From: Willett Technical Services. Andy.Willett <[REDACTED]>
Sent: 30 November 2017 16:34
To: Charlotte Burrows
Cc: Jules Mob Pers
Subject: Re: Millhouse Croft attention Mrs C Burrows A/195/17/HH

From: Willett Technical Services. Andy.Willett [REDACTED]
Sent: 13 November 2017 21:49
To: Planning [REDACTED]
Subject: Millhouse Croft attention Mrs C Burrows A/195/17/HH

BLOCK/SITE PLAN
AREA 130m x 130m A3
SCALE 1:500
CENTRE COORDINATES: 508676, 103748

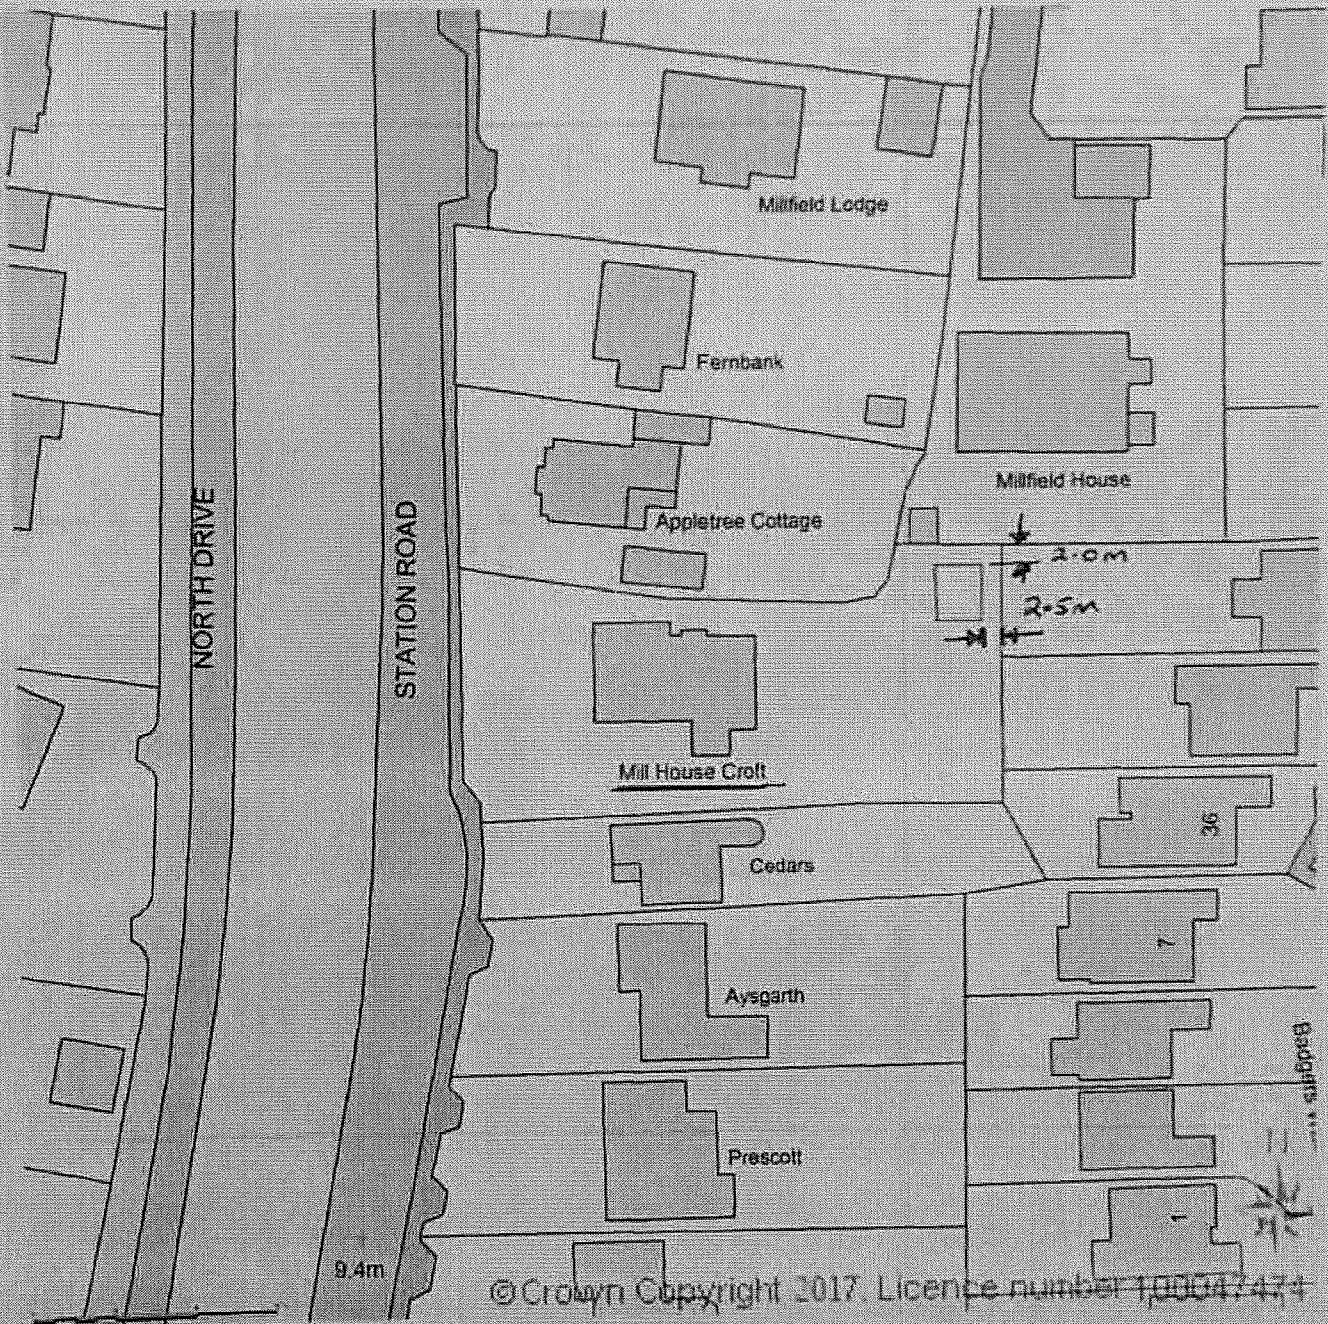
It is the Location plan we require and that should be at a scale of 1:1250 or for more rural sites 1:2500.

We require a Location plan, this would look similar to the submitted Block plan but would be at a scale of 1:1250.

Code	2017-472	Sheet	2
Drawing	Wall A	Scale	1:50
Material	7.0x13.5	Date	16.08.2017
Designed by	Tuindeco	File	2017-472.dwg

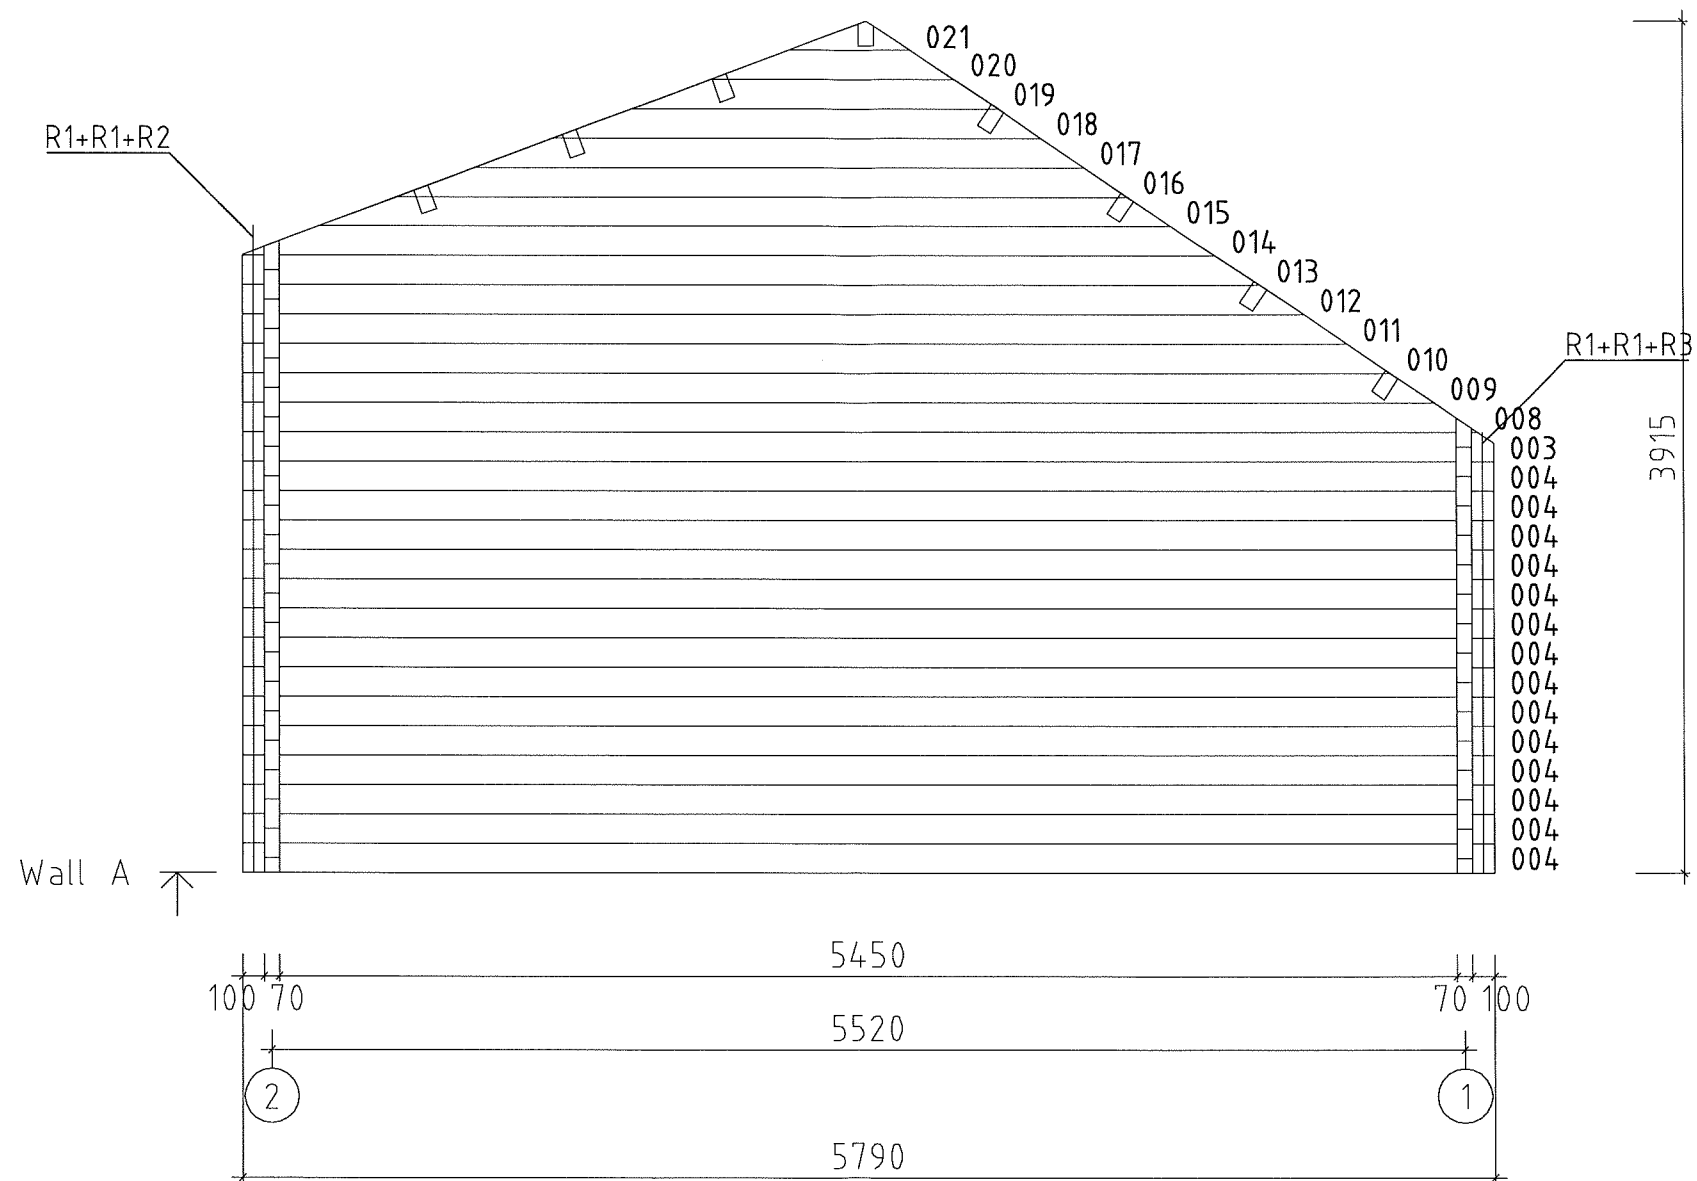
Also, with regard to your other email relating to the elevations. They seem to be called 'wall 1' or 'wall B' on the printed out plans, would it be helpful for me to post a hard copy back to you for you to amend by hand and return? If so please just let me know.

Also, we would ask you label the submitted elevations as to whether they are rear/side/front elevations.
